East Yorkshire Solar Farm
EN010143

Statement of Common Ground between East Yorkshire Solar
Farm Limited and the Ouse and Derwent Internal Drainage
Board

Document Reference: EN010143/APP/8.16

~~15 August 5 June~~ 2024
Revision Number: 001

FIGURE TITLE
Drain Names
Sheet 2 of 3

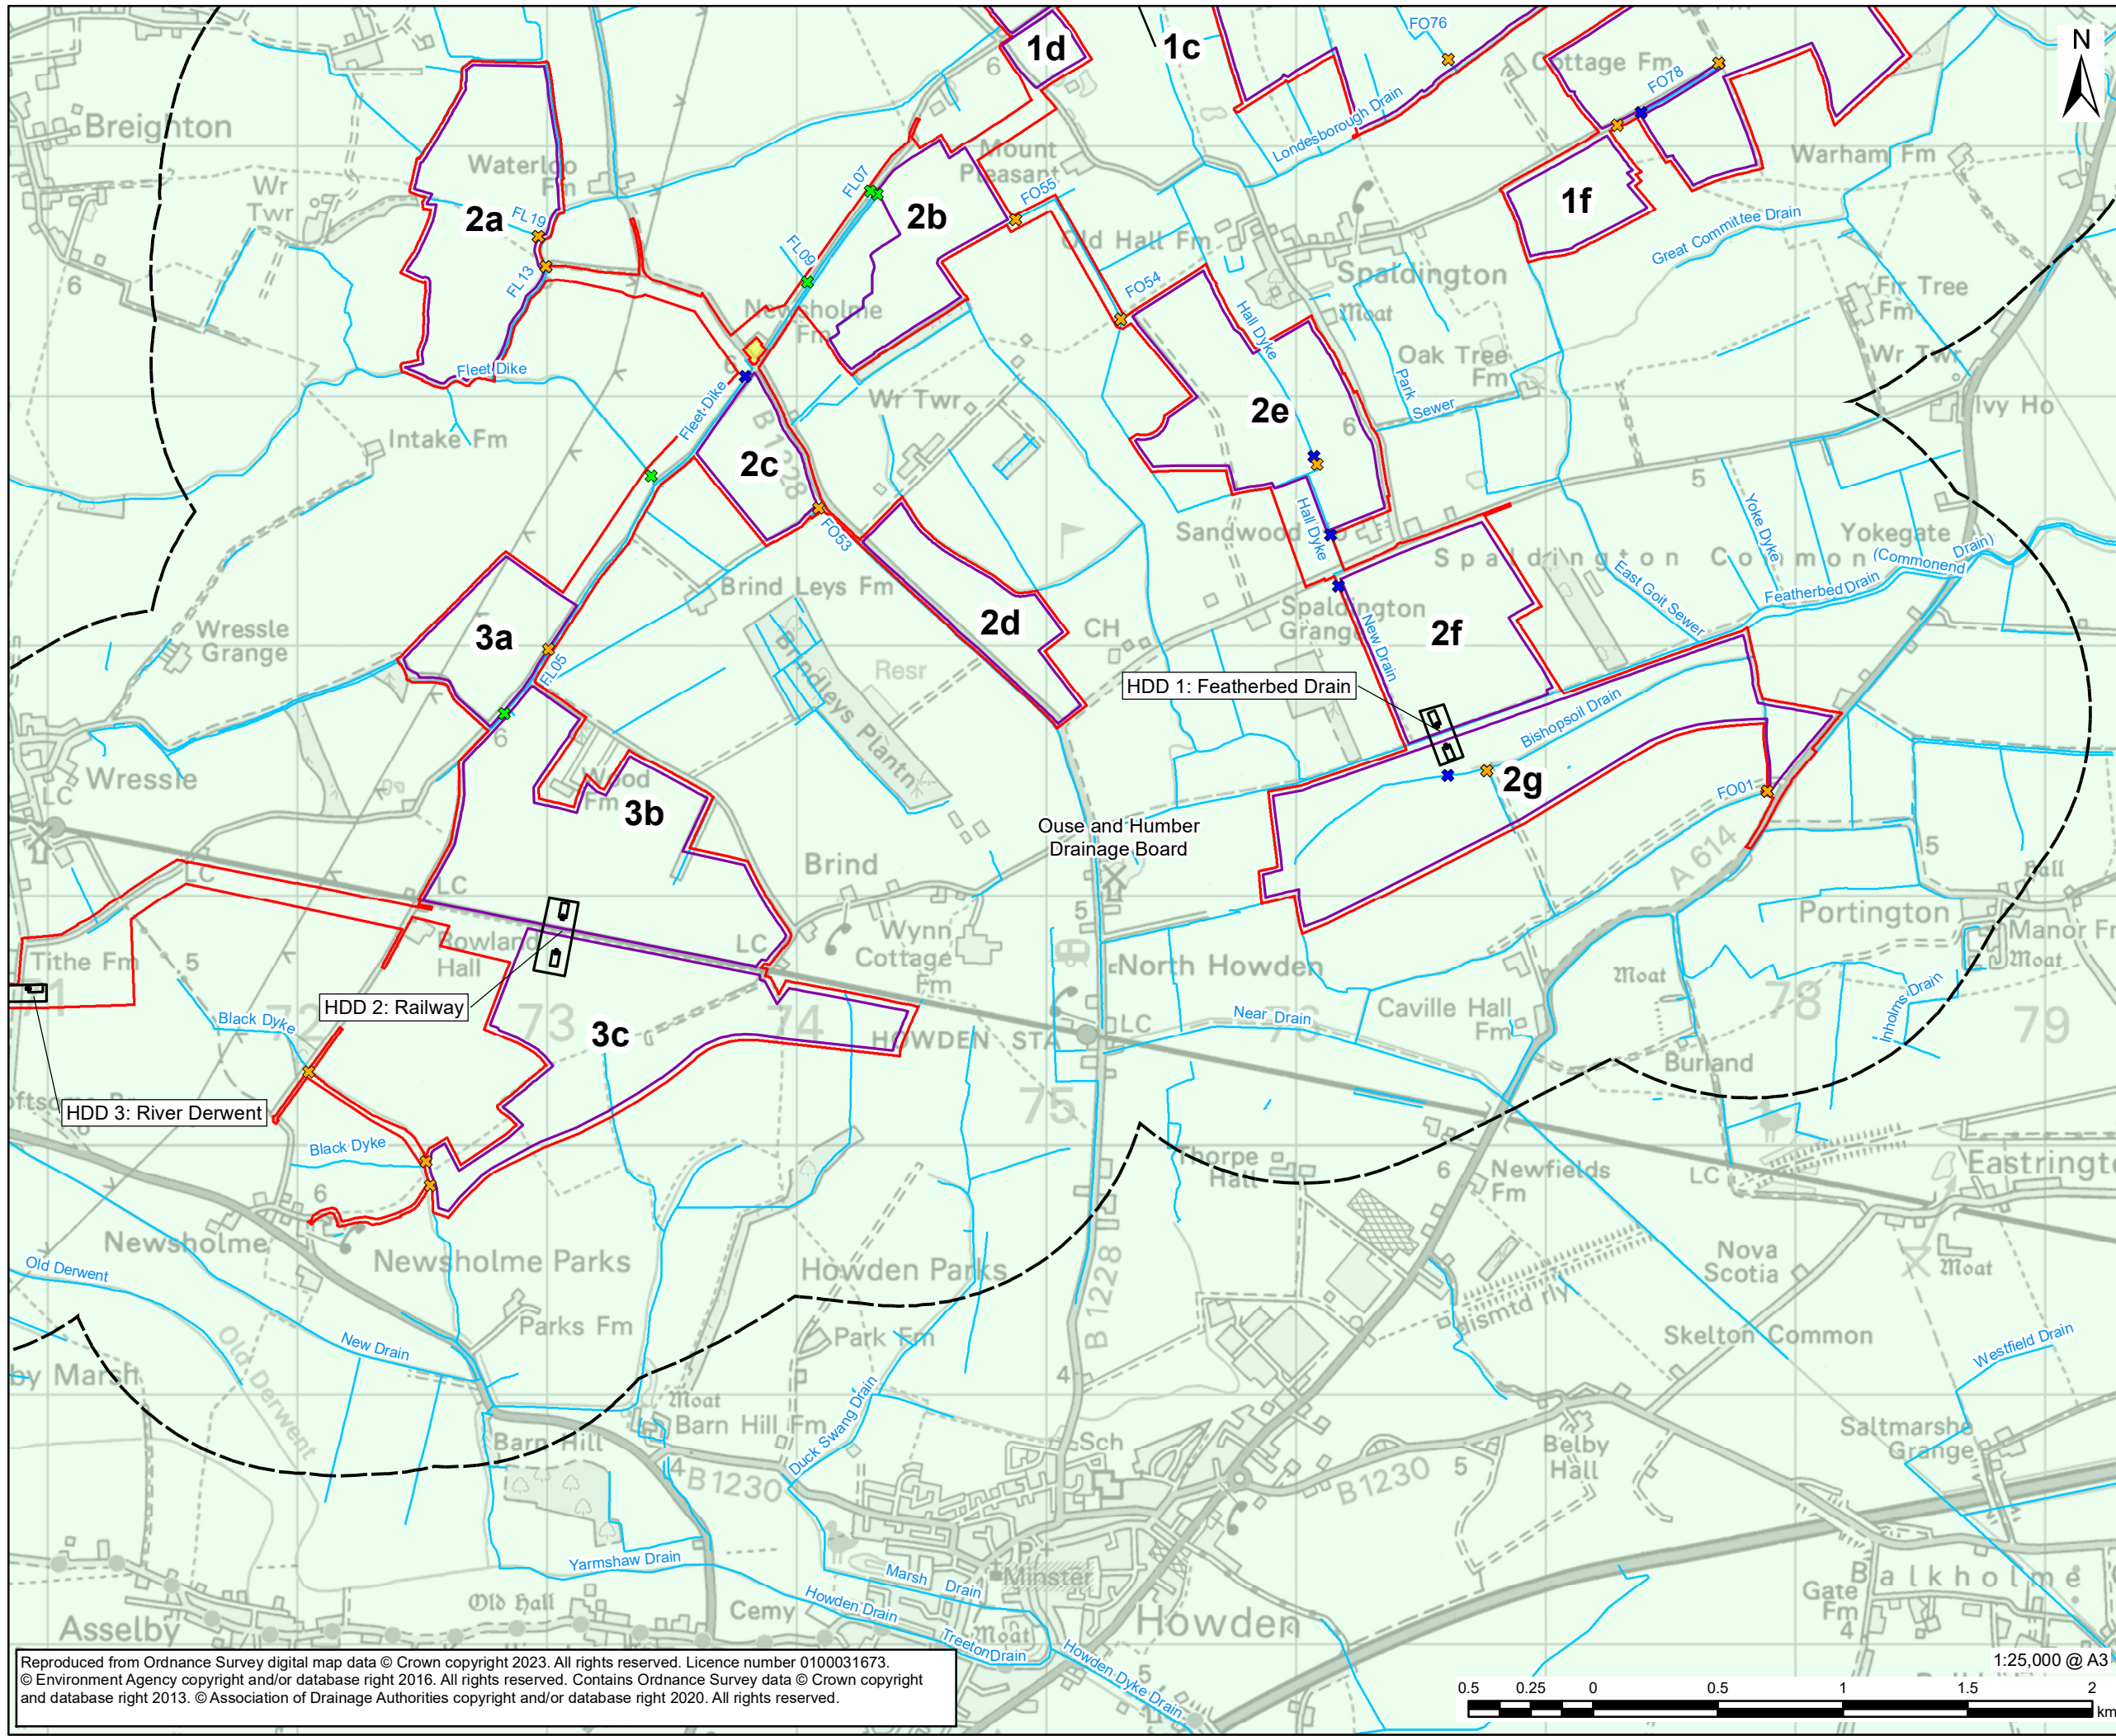
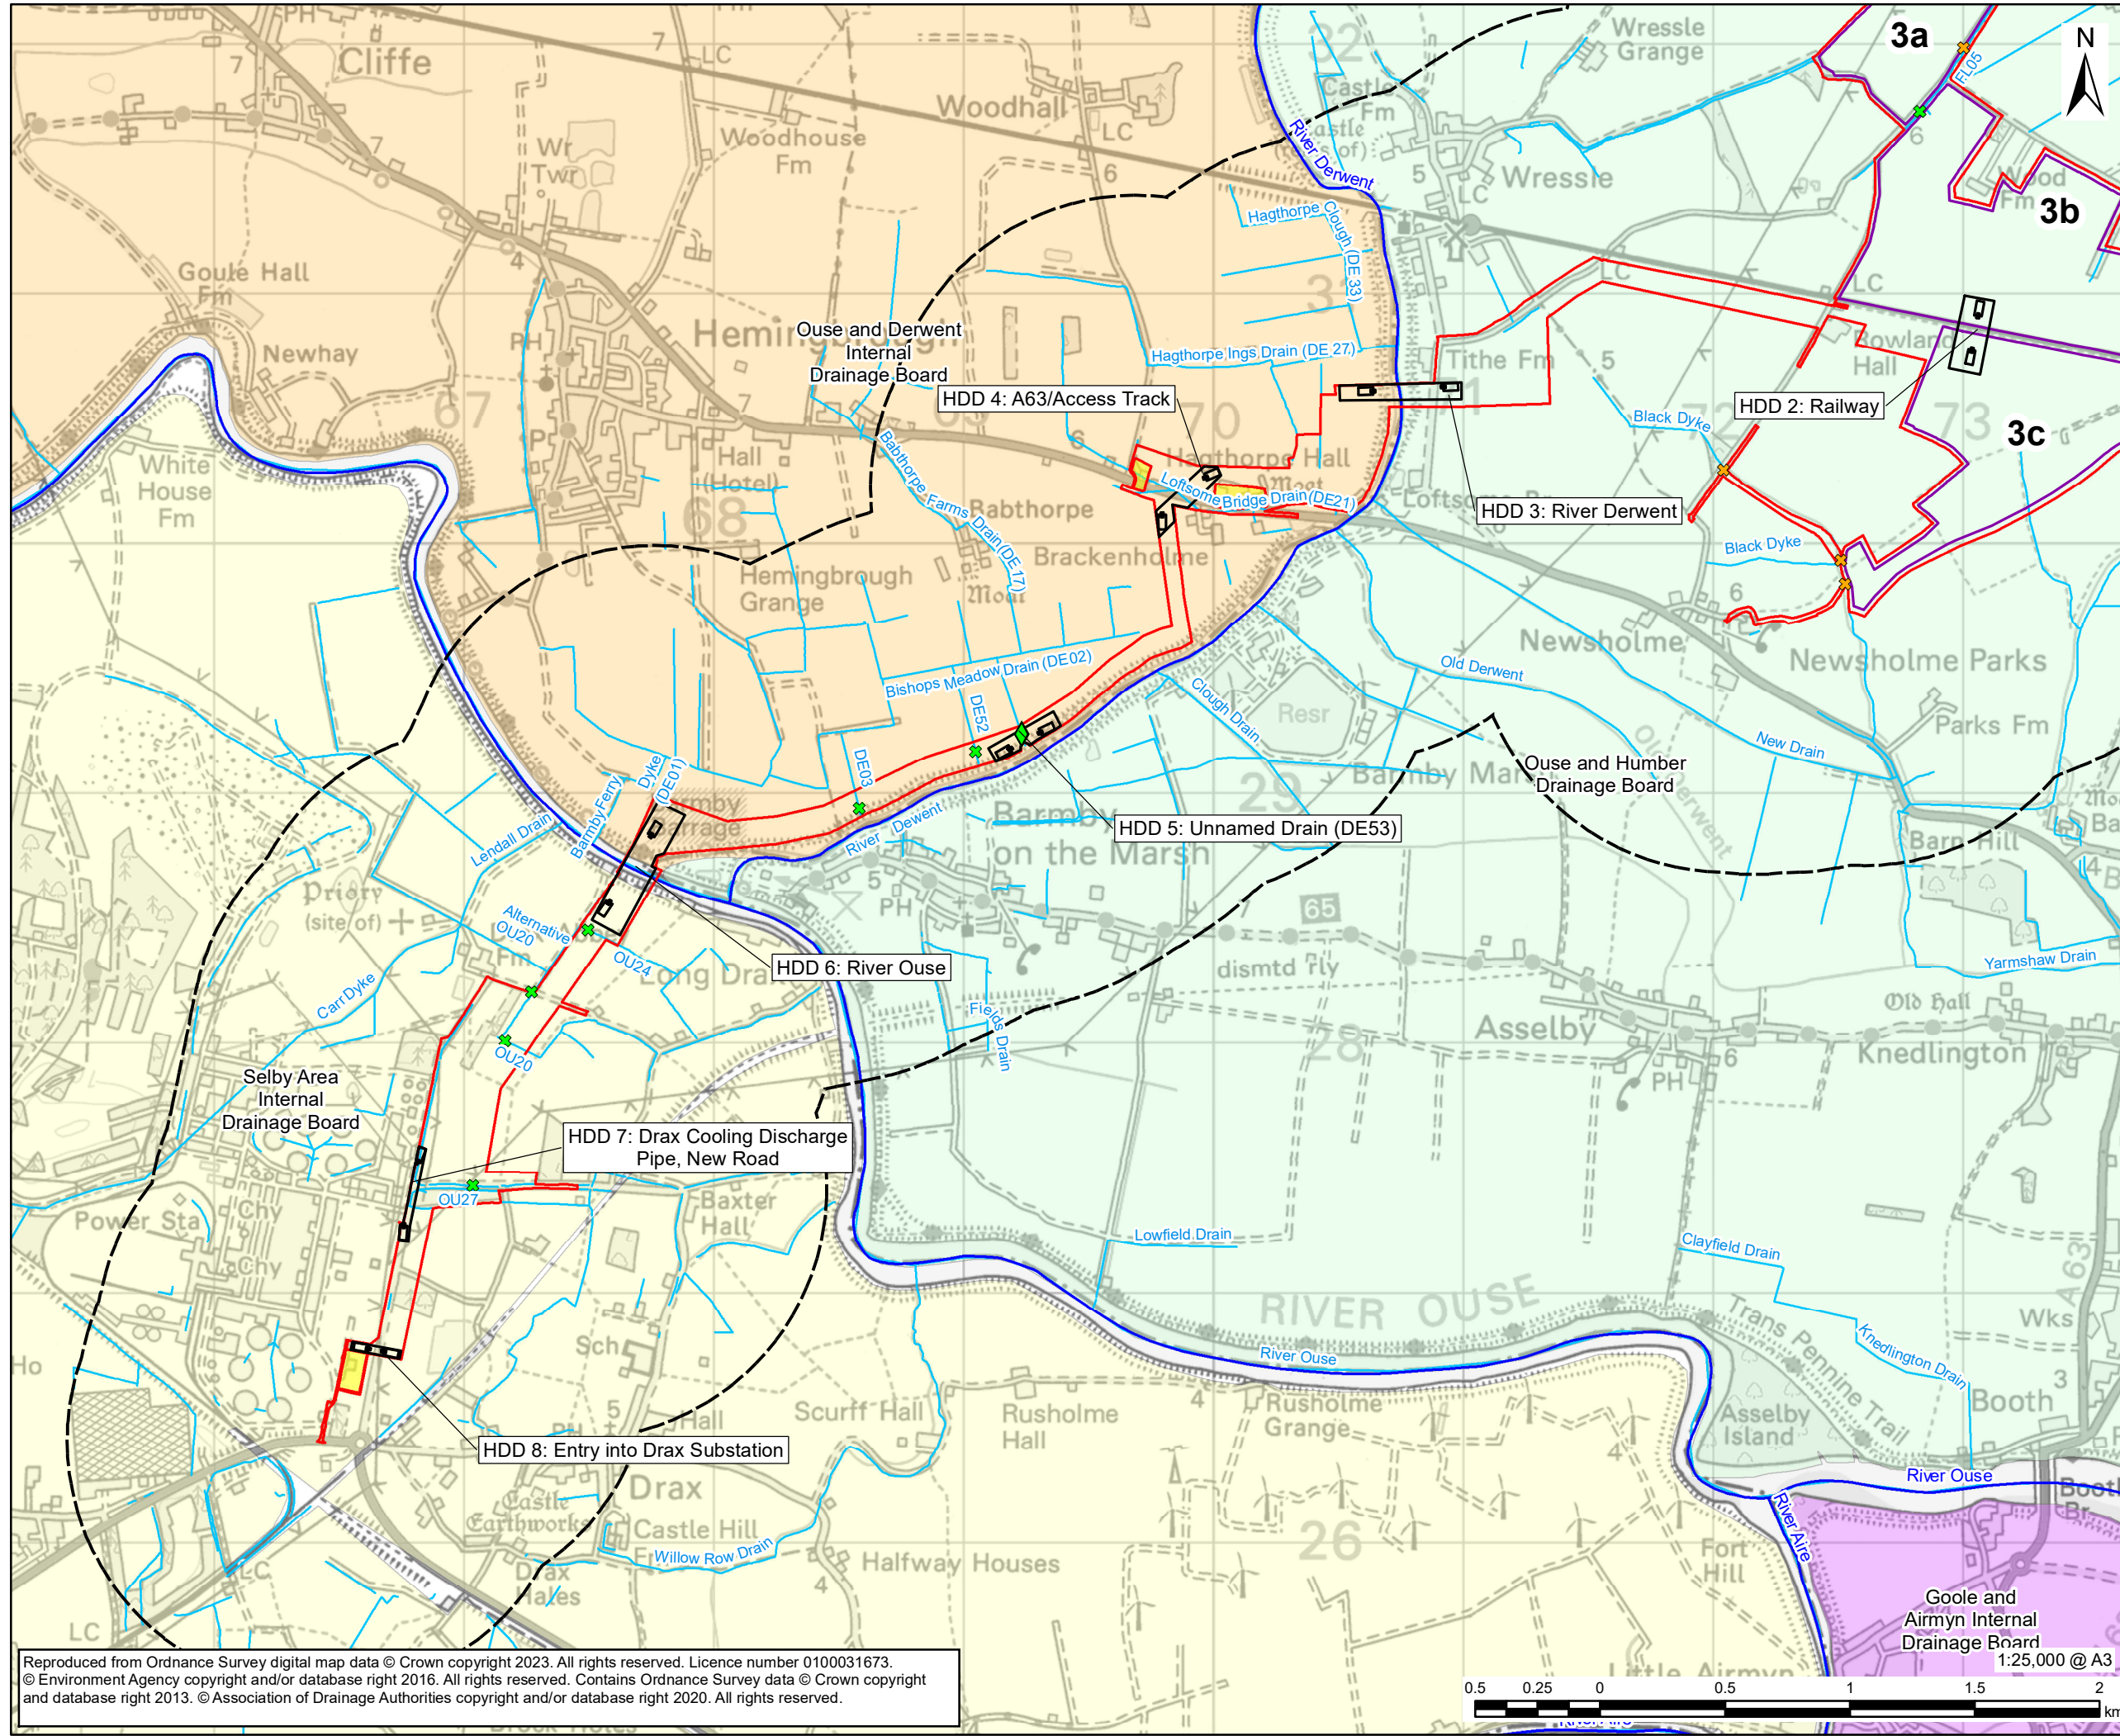
3.1.3	Relevant Representation	Relevant watercourses	<p>The Ouse and Derwent IDB note that using Figure 9-2: Drain Names (Sheet 3 of 3), ES Volume 3 [APP-152], the Ouse and Derwent IDB will be looking at the below watercourses which may/will be effected: <u>affected:</u></p> <p>1. Drain DE21 – this is the Ouse and Derwent IDB</p>	The Applicant accepts that the Ouse and Derwent IDB will be looking at the watercourses identified in their relevant representation.	Agreed
